Final Report - Corrections Required **Application No. ZONE-25-0021**

Record Type : Zone Change

County File: OAR2512 – Banning Lewis Ranch Village C – Review 2

City File: ZONE-25-0021

ISSUE RECORD

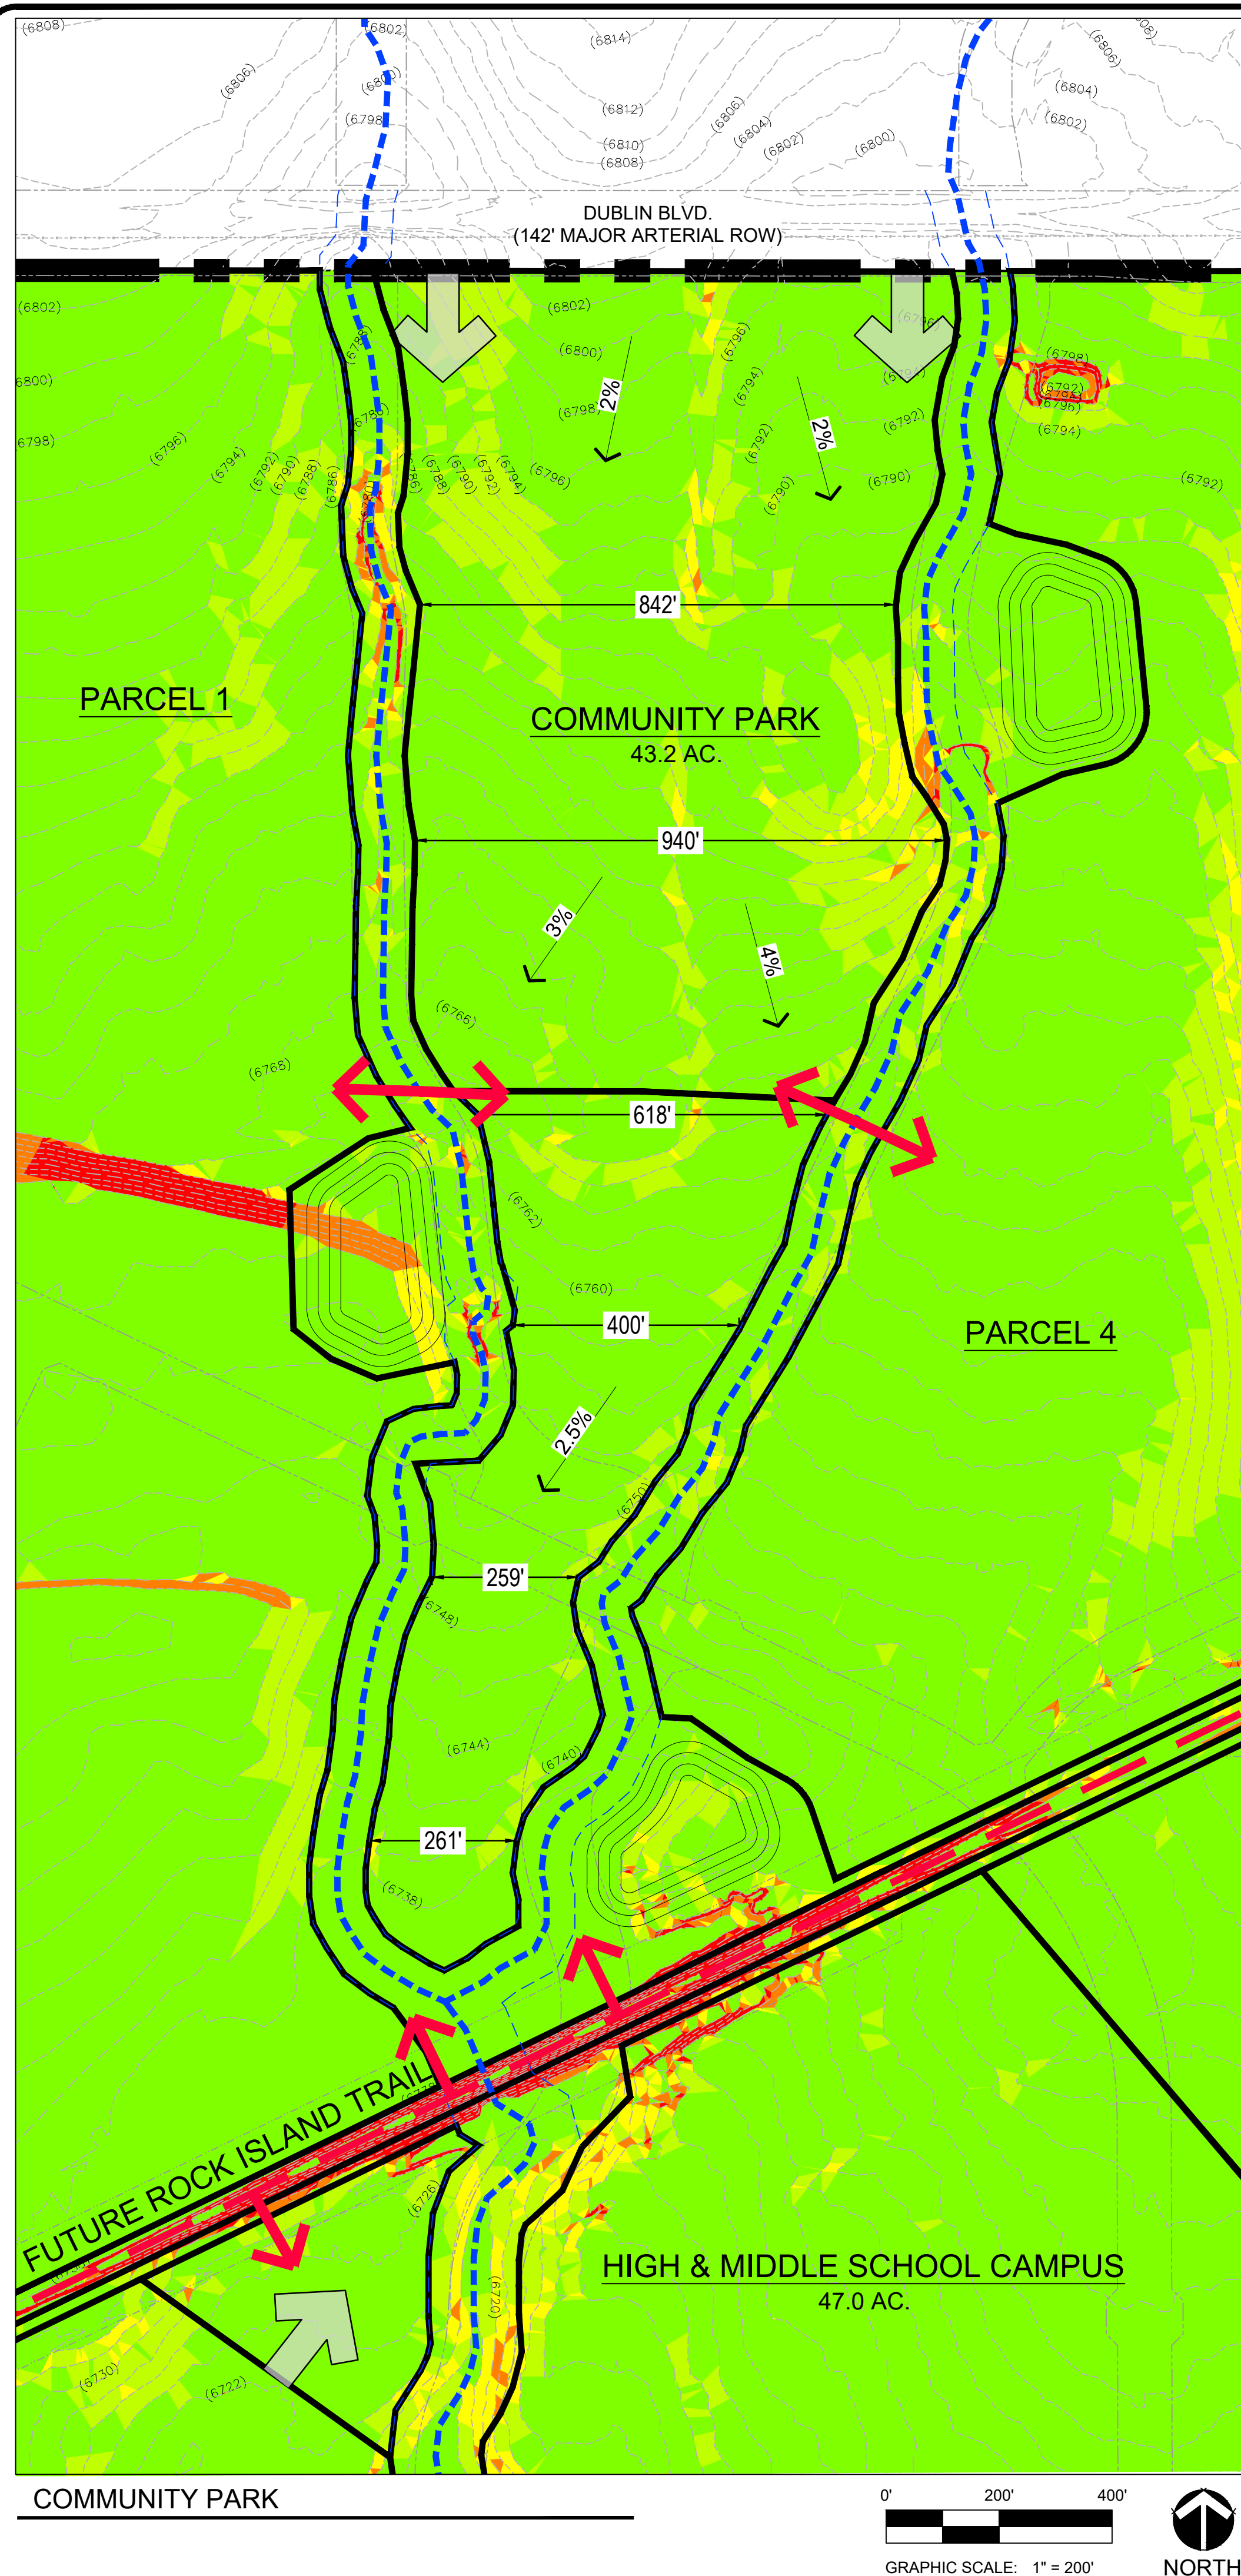
Comment ID	Reviewer : Department	Review Comments
20	Chris Padilla : COS Airport	Action Items: 8/4/2025: This action item was approved by the AAC, please provide proof of Avigation Easement. This item will be reviewed by the Airport Advisory Commison on 7/23/2025 with the below action item for Parcel # 5300000733. • Avigation Easement: An avigation easement is required or provide proof of previous recording (book/page or reception number). Add avigation easement note to plat.
